Subject: A30 Chiverton to Carland Cross Improvement Scheme

TN1 – REVIEW OF TRAFFIC MODELLING DATA

19TH JUNE 2019

A30 Carland to Chiverton 12 Hour Traffic Flows (AM Peak Period) - October 2014 / March 2015

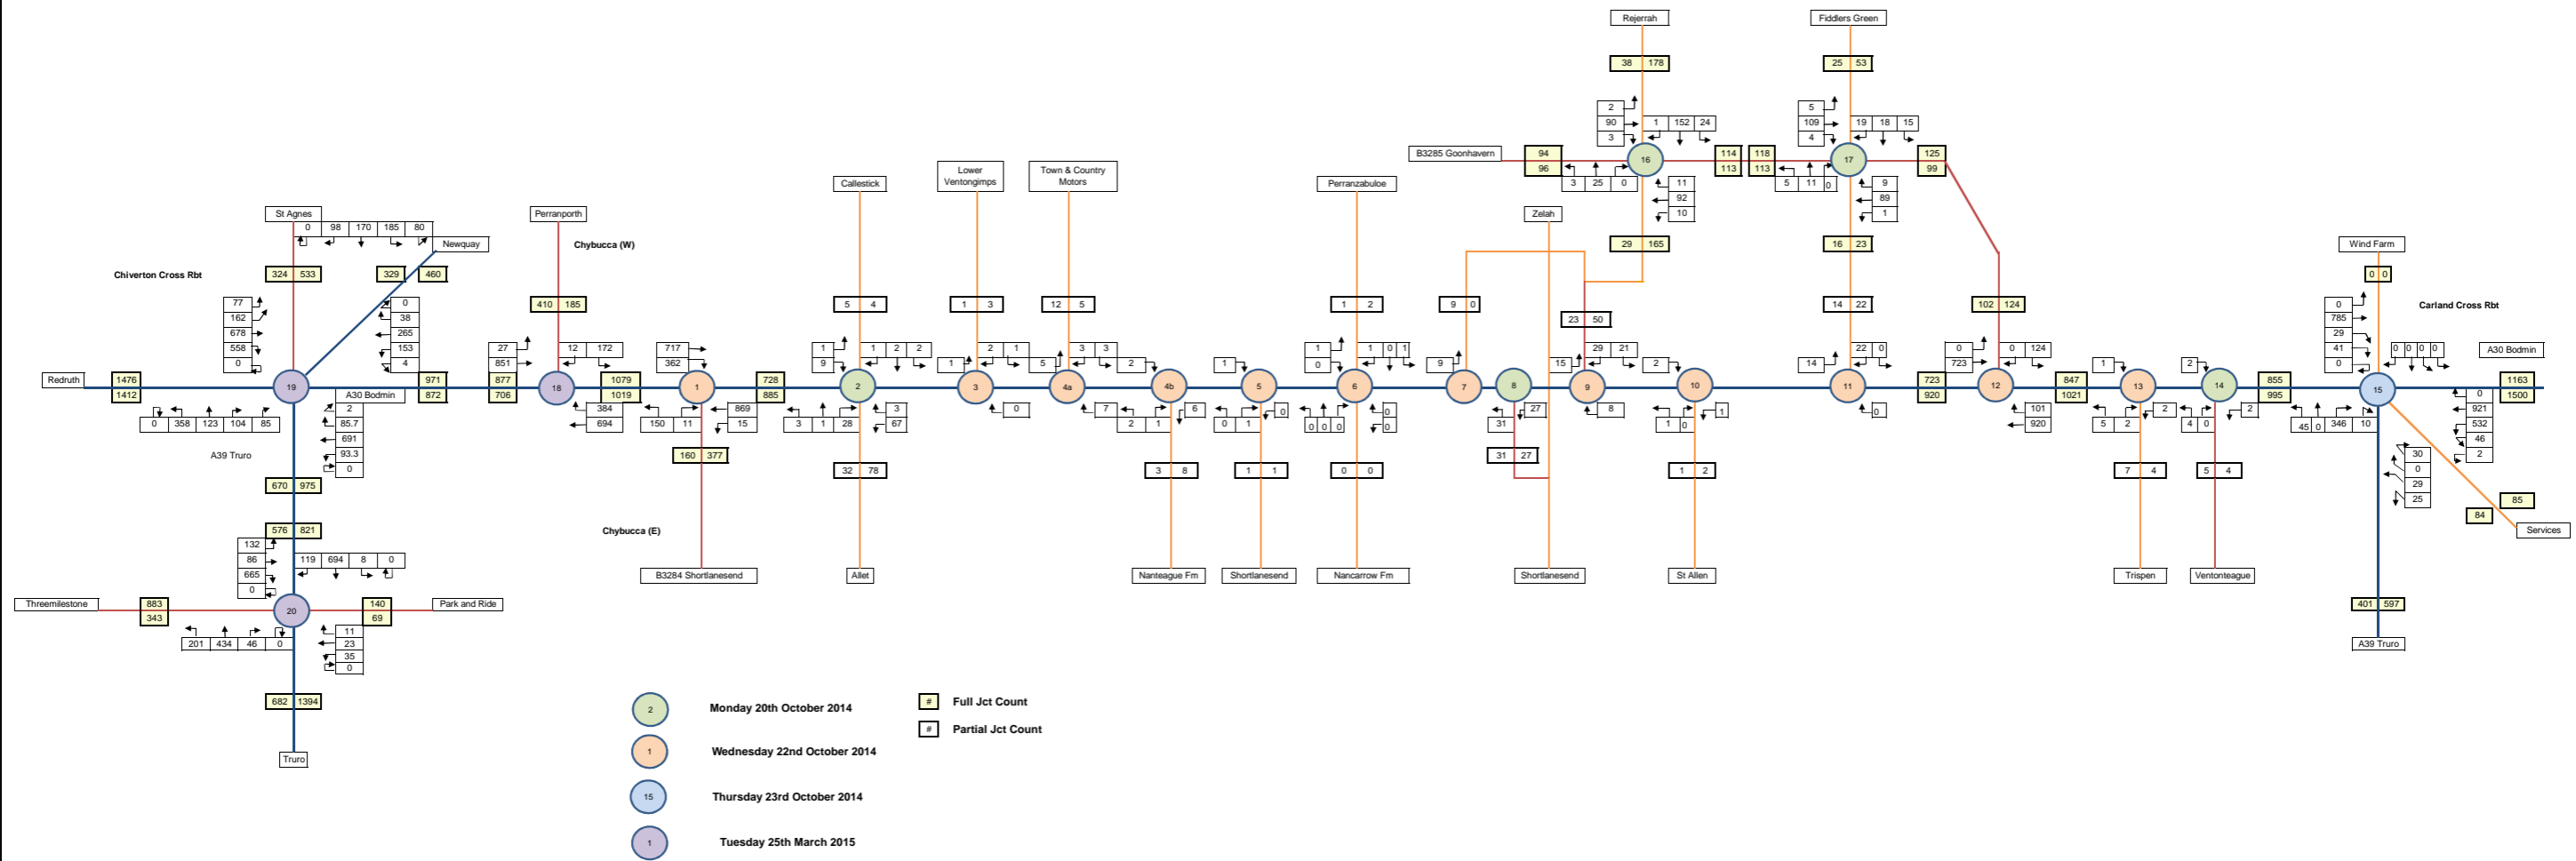
-
- 4.3 Reviewing the right turning traffic at Chybucca (W) from A30 westbound to the B3284 "Perranporth" northwest bound, the TDCR MCC data suggests 384 movements, the LMVR "Observed" (Origin Destination matrix movement C to B) shows 39 movements, and the LMVR "Modelled" shows 96 movements.

- 4.4 There is no explanation as to why the TDCR MCC and LMVR "Observed" movements differ by, in this case, a factor of 10.
- 4.5 Turning to whether this traffic is genuine A30 westbound to B3284 northwest bound, or B3284 (from Truro / Shortlanesend) to B3284 northwest bound, there is no direct survey evidence to determine the absolute number (as the two parts of the Chybucca junction have been surveyed separately).

- 4.6 It could be that the majority of B3284 (from Truro / Shortlanesend) left turn to A30 westbound are, in actuality, heading across the A30 to B3284 northwest bound. Even if this were the case that all 150 left turning vehicles (as per the TDCR MCC) also turn right towards the B3284 northwest bound "Perranporth", then there are at least 234 vehicles turning right from the A30 westbound (from the A30 east of Chybucca (E)) towards the B3284 northwest bound "Perranporth".

- 4.9 On the face of it, there are two points to be drawn from this:
- The model does not appear to reflect the most recently collected traffic turning count data in the AM Peak.

- The most recent turning count data appears to suggest demand for east facing slip roads in the AM Peak of at least 234 vehicles turning from the A30 westbound to the B3284 towards Perranporth.

A30 Carland to Chiverton 12 Hour Traffic Flows (PM Peak Period) - October 2014 / March 2015

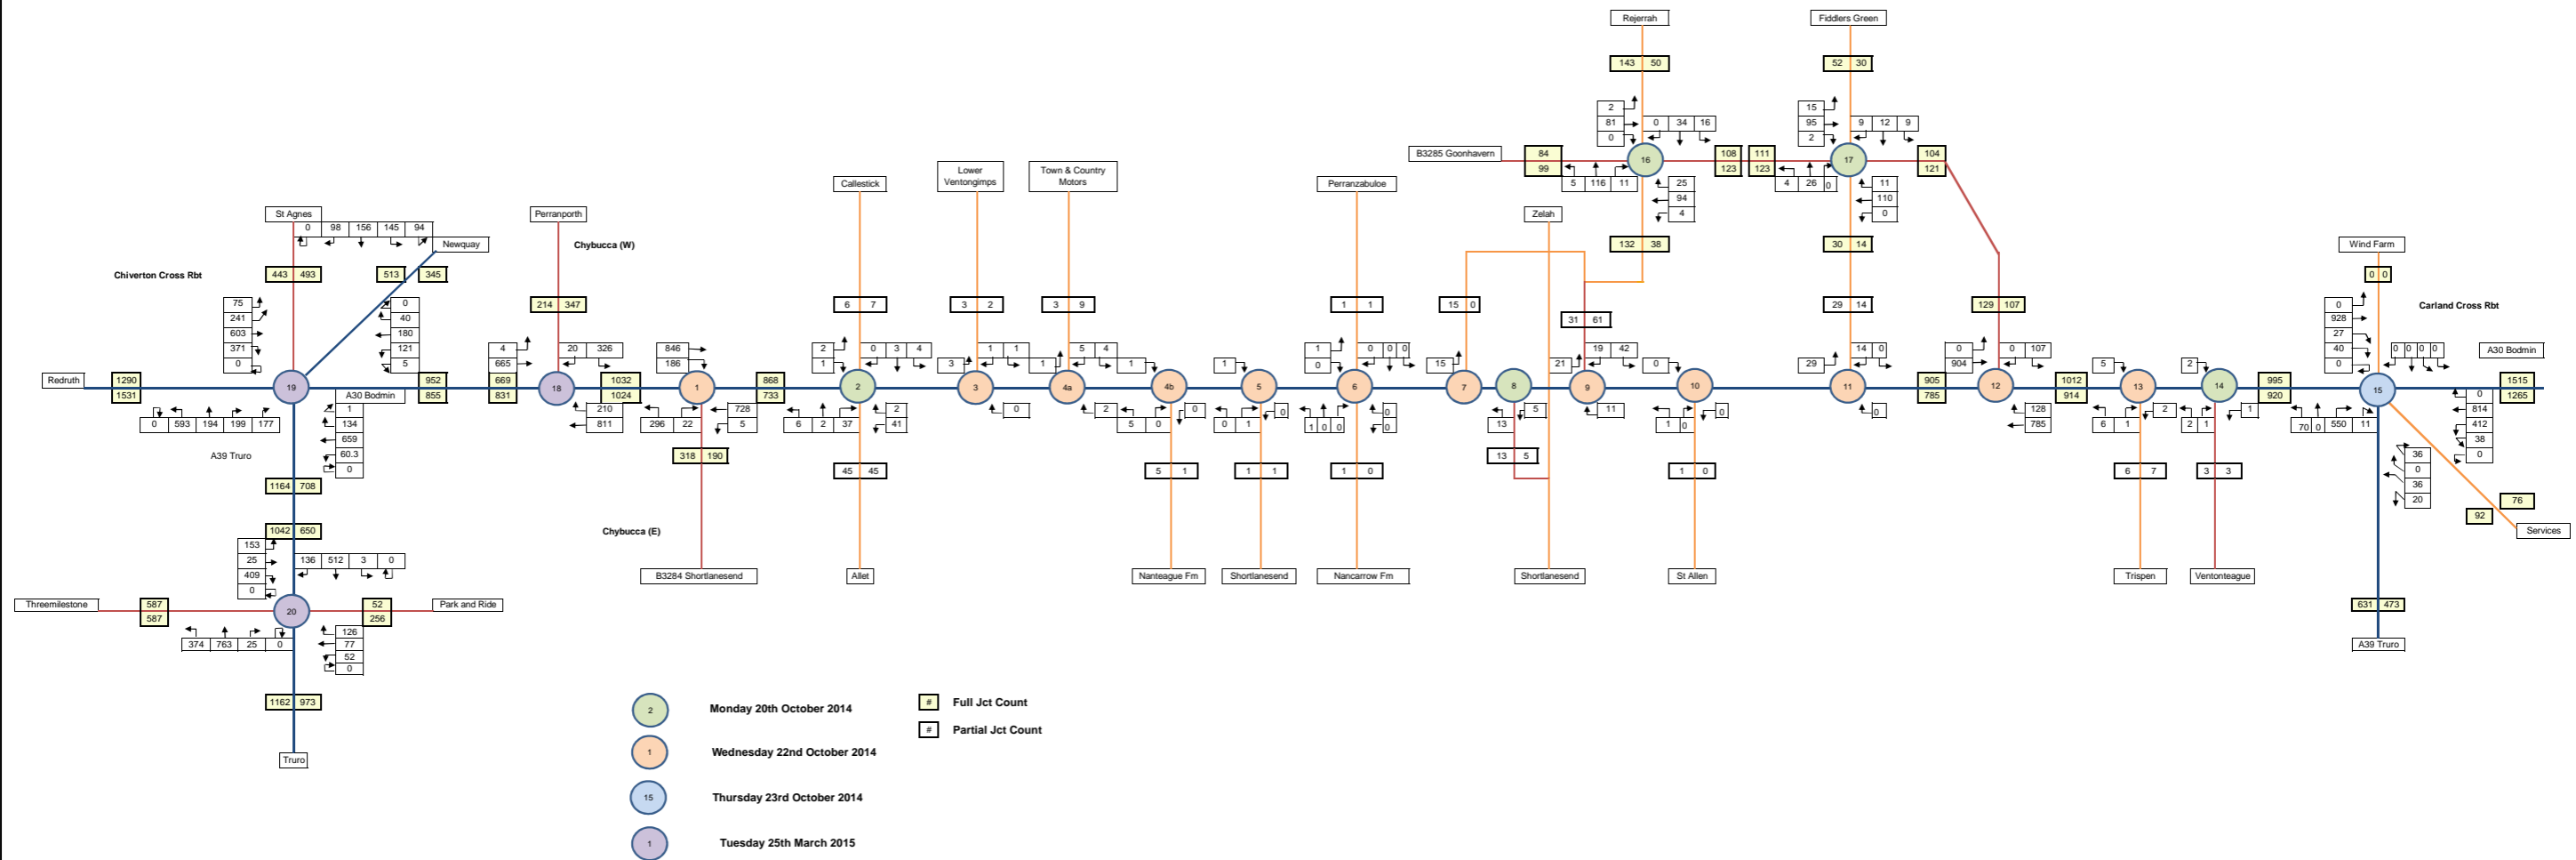
- 4.11 Reviewing the left turning traffic at Chybuca (W) from the B3284 "Perranporth" southeast bound to the A30 eastbound, the TDCR MCC data suggests 326 movements, the LMVR "Observed" (Origin Destination matrix movement B to C) shows 56 movements, and the LMVR "Modelled" shows 108 movements.

- 4.12 There is no explanation as to why the TDCR MCC and LMVR "Observed" movements differ by, in this case, a factor of 6.
- 4.13 Turning again to whether this traffic is genuine B3284 southeast bound to A30 eastbound, or B3284 southeast bound towards B3284 (to Truro / Shortlanesend, i.e. across the A30), there is no direct survey evidence to determine the absolute number.

- 4.14 It could be that the majority of right turns from the A30 eastbound to B3284 (to Truro / Shortlanesend) are, in actuality, heading across the A30 to from the B3284 "Perranporth". Even if this were the case for all 186 right turning vehicles (at Chybucca (E), as per the TDCR MCC), then there are 140 remaining vehicles recorded to turn left from B3284 Perranporth on to the A30 eastbound.

- 4.17 On the face of it, there are two further points to be drawn from this:
- The model does not appear to reflect the most recently collected traffic turning count data in the PM Peak.

- The most recent turning count data appears to suggest demand for east facing slip roads in the PM Peak of at least 140 vehicles turning from the B3284 from Perranporth on to the A30 eastbound.
